From: Adrian Dowd
Sent: 31 January 2018 14:43
To: Sharon Craig
Subject: FW: 3/2018/0013 - Brabins Almshouses 21 Kirklands Chipping Preston PR3 2GD - SPAB Response

Application ref: 3/2018/0013

Development Address: Brabins Almshouses, 21 Kirklands, Chipping, Preston PR3 2GD

Proposal: External repointing using lime mortar, internal re-plastering using lime plaster, replacement of lead flashings to chimney stacks, replacement of damaged stone flags on front and rear roof pitches, removal of part of ridge beam above 29 Windy Street and replacement with new timber.

drawing title:
Elevations

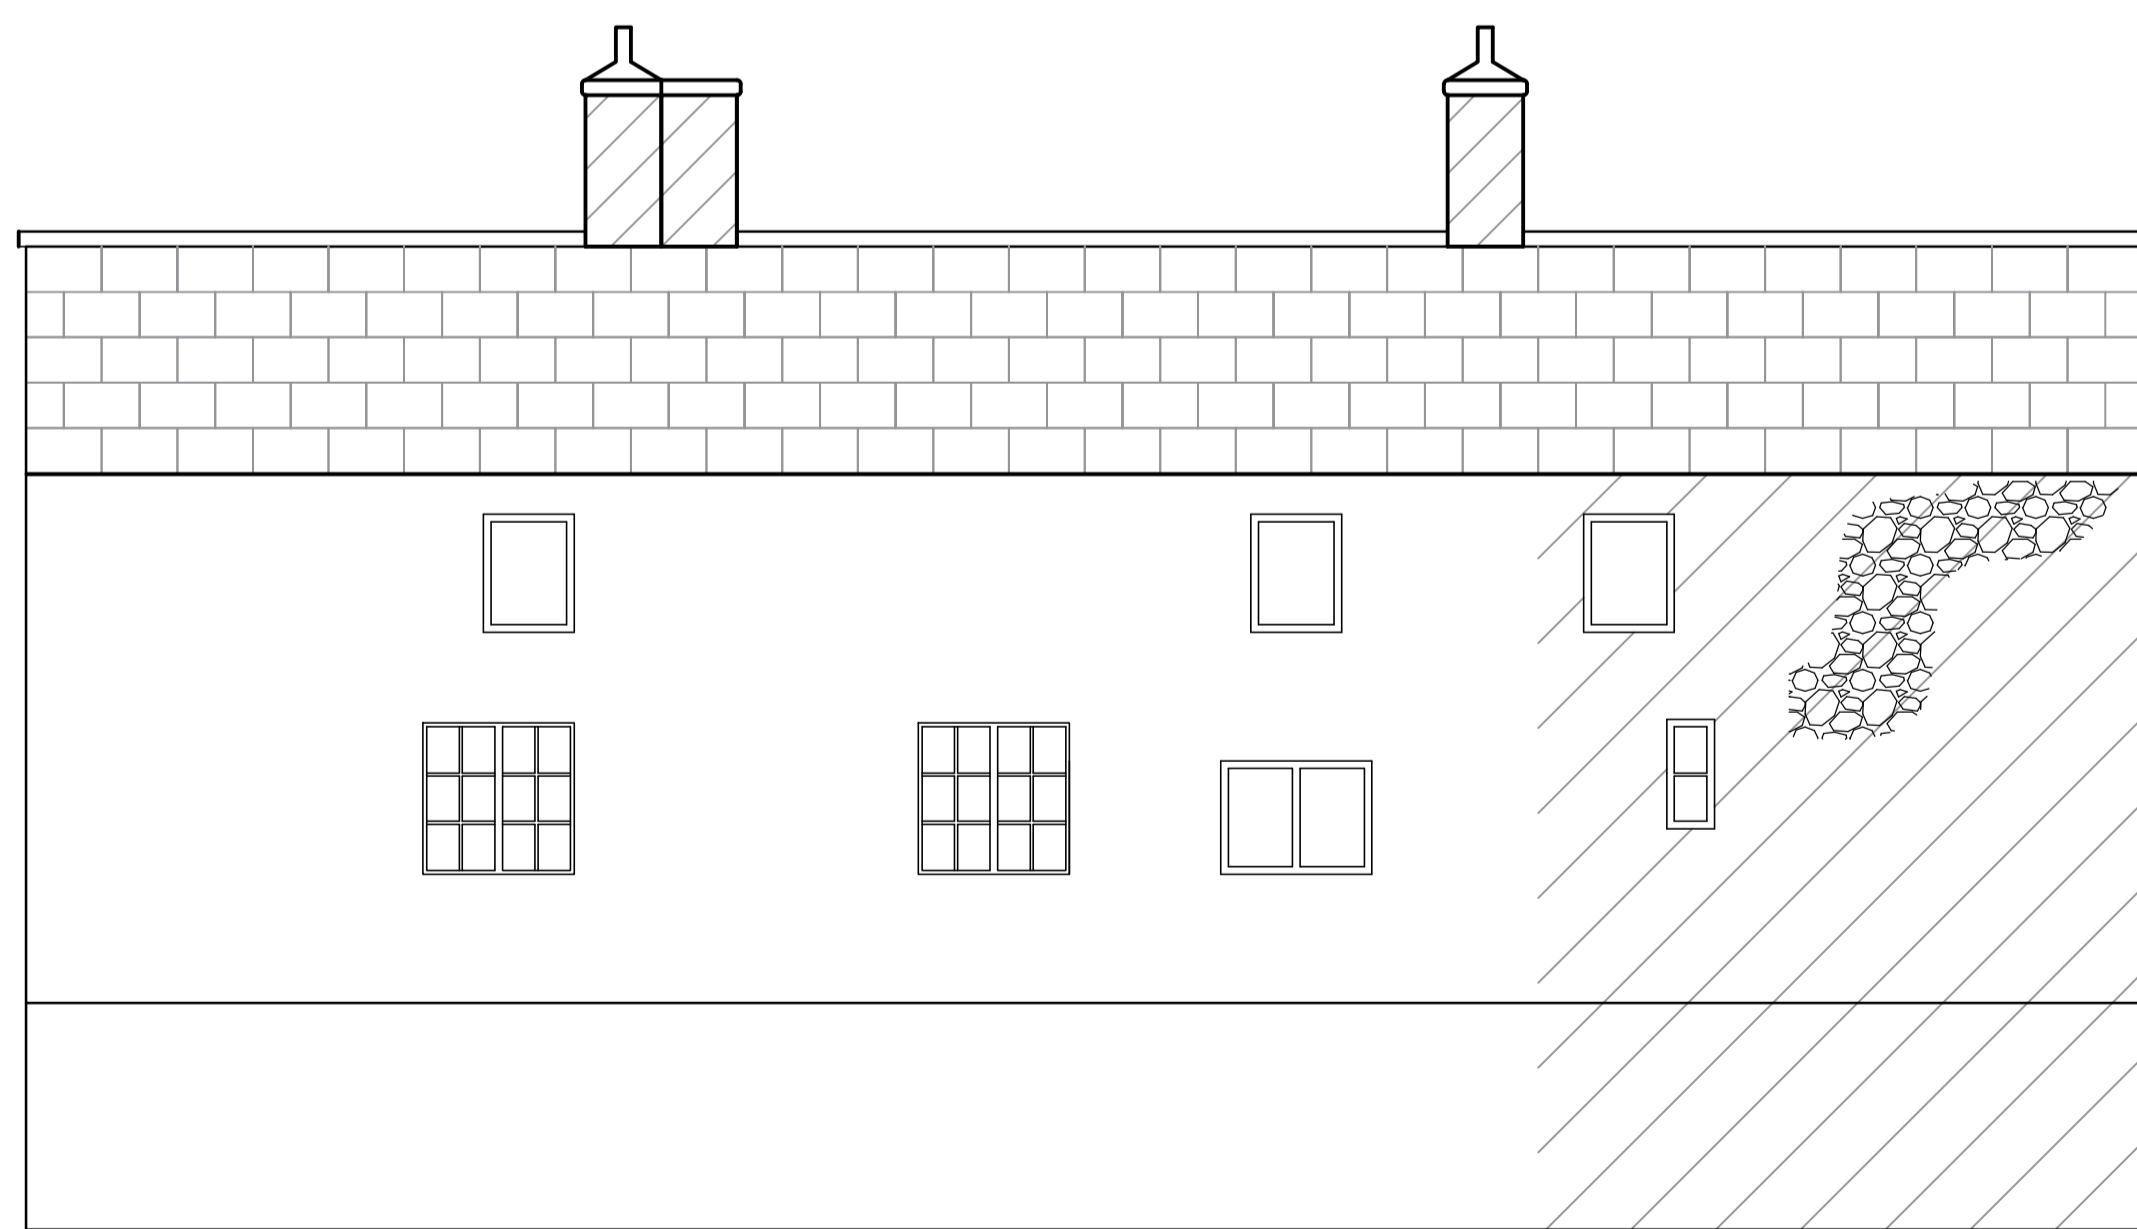
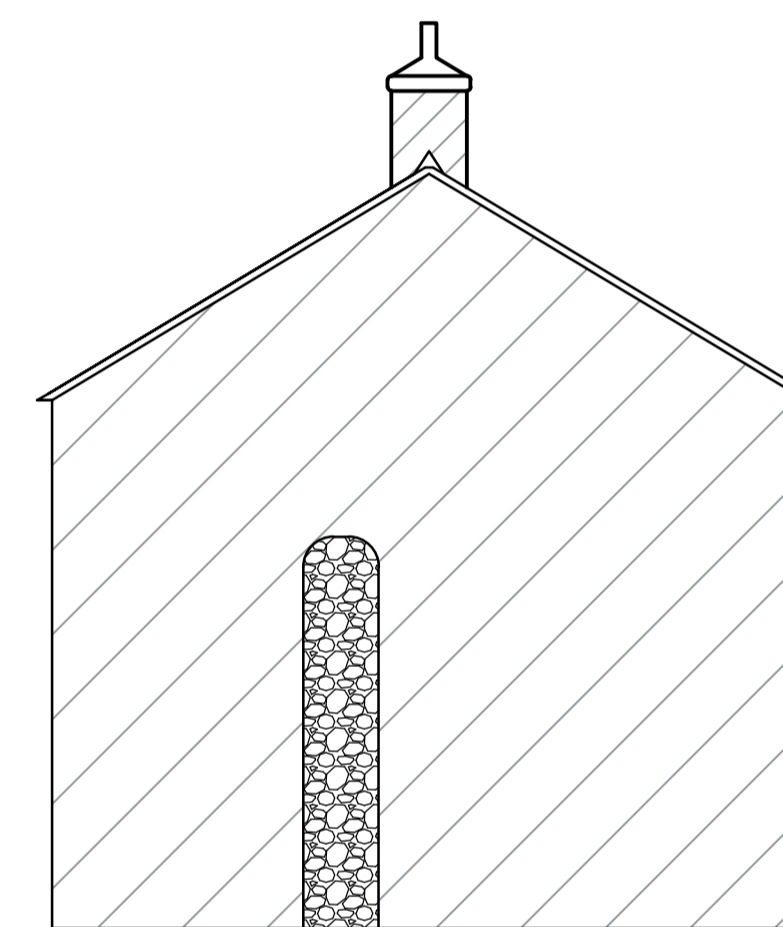
The supporting information explains the reasons for the proposed repairs and demonstrates a good level of understanding of both the construction and behaviour of traditional buildings and materials. The proposal is to replaster and repoint using lime but no further details are given in respect of specifications. We advise therefore that these details are discussed and agreed prior to determination of the application, or that your authority request, via conditions, that this information is submitted and agreed in writing before development commences.

Once the inappropriate materials have been removed, we strongly encourage that the building is given sufficient time to dry out and regain its natural equilibrium before it is repointed and replastered. We would also encourage that lime putty is used in favour of NHLs given the ongoing concerns and emerging research in respect of the appropriateness of their use in some historic building contexts. Should you or the agent wish to discuss any technical aspects of the proposed repairs (plaster, pointing, roofing, damp), or any aspect of our advice, please do not hesitate to contact me or my colleague Jonathan Garlick - SPAB Technical Officer (jonathan@spab.org.uk). Alternatively, you may telephone our free Technical Advice Line: 020 7456 0916. Mon-Fri 9.30am-12.30pm where one of our Technical Officers would be pleased to speak with you.
